Consultation Response from KC, Highways Development Management
2026/91349 23, High Street, Scapegoat Hill, Huddersfield, HD7 4NJ
Alterations to convert offices to 2 flats
Date Responded: 25 June 2026 Responding Officer: Sheila Henley Responding Ref: 2-4/19

Plan ref: 25HS_P02 _ Proposed.

Dwg ref: 23HS/P02 : Scale 1:100 @ A3 : May 2026

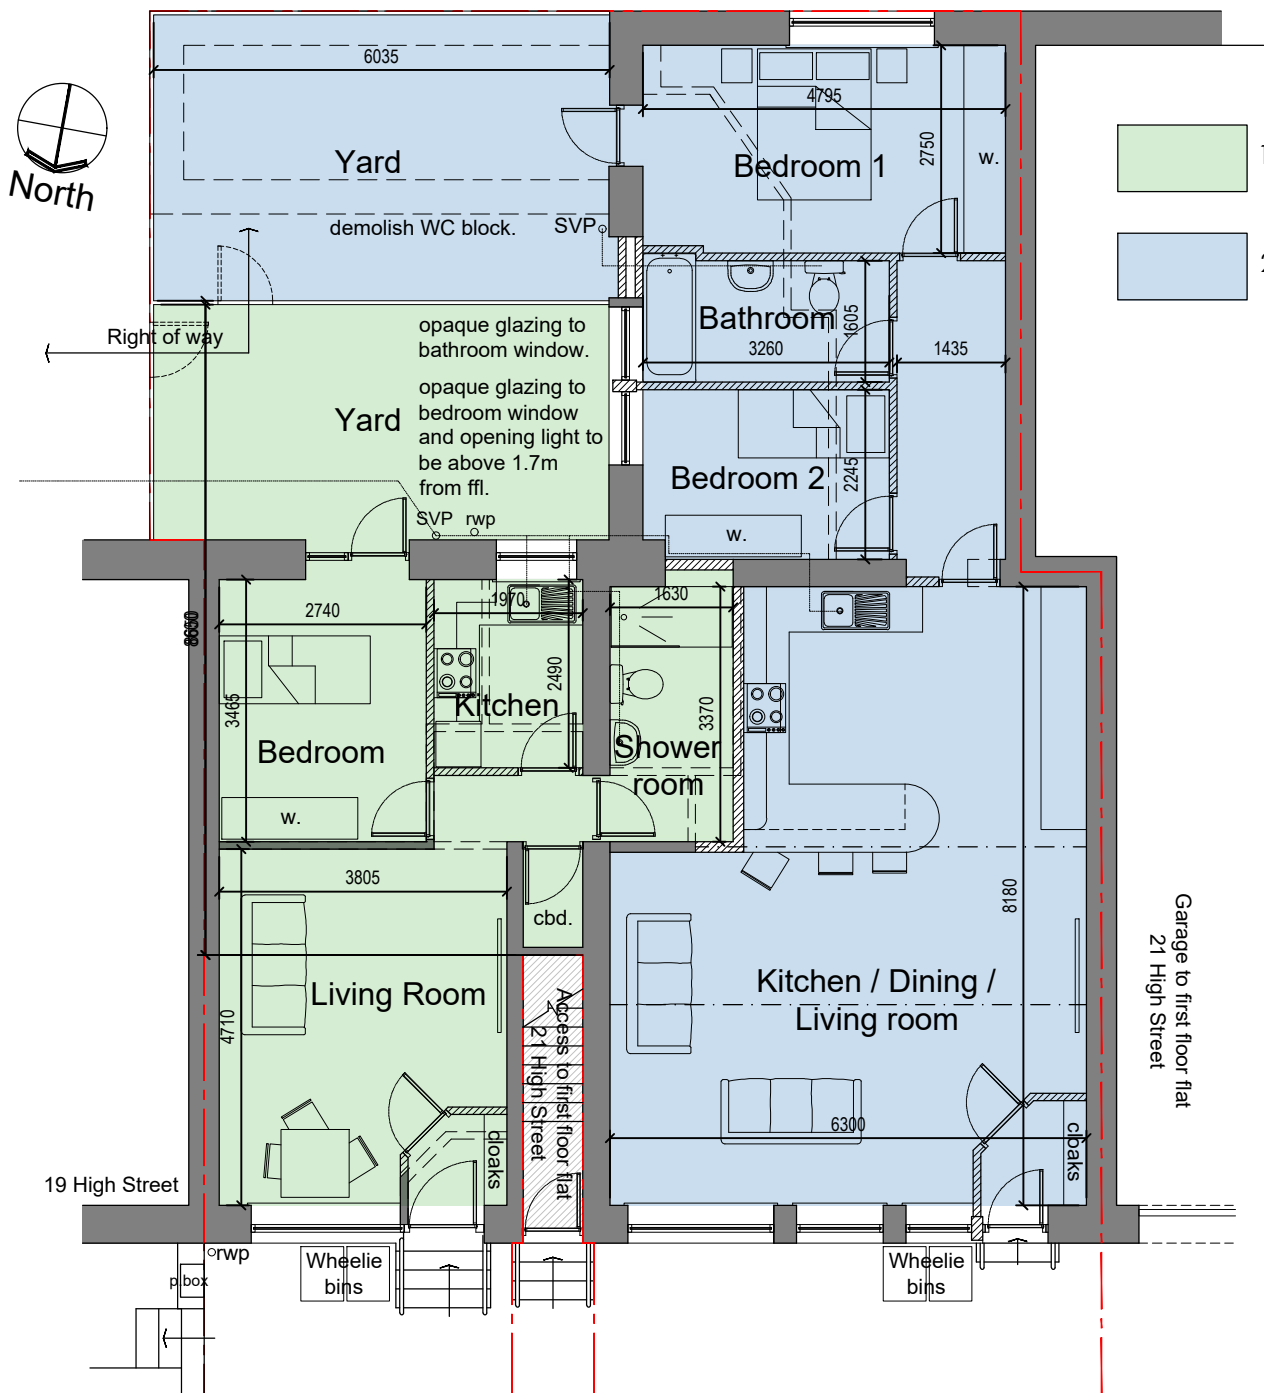
No cycle parking is indicated. The yards provide an option for an enclosed and secure storage for each unit if access is available. There appears to be a right of way, but this may not be available on a regular basis given it is for maintenance purposes and there would need to pass through the adjacent property as well as passage through the existing yard to reach proposed second yard.

Bin storage is shown within the 2m curtilage in advance of the building line which is acceptable from the highway perspective since this area falls outside of the extent of the public road, assuming clearance of any retained or new meters and the post box. Yet, there could be negative impact on the streetscene. Additionally, it may be prudent for the LPA to consult the Waste Collection Service to confirm that the provision and location are acceptable.
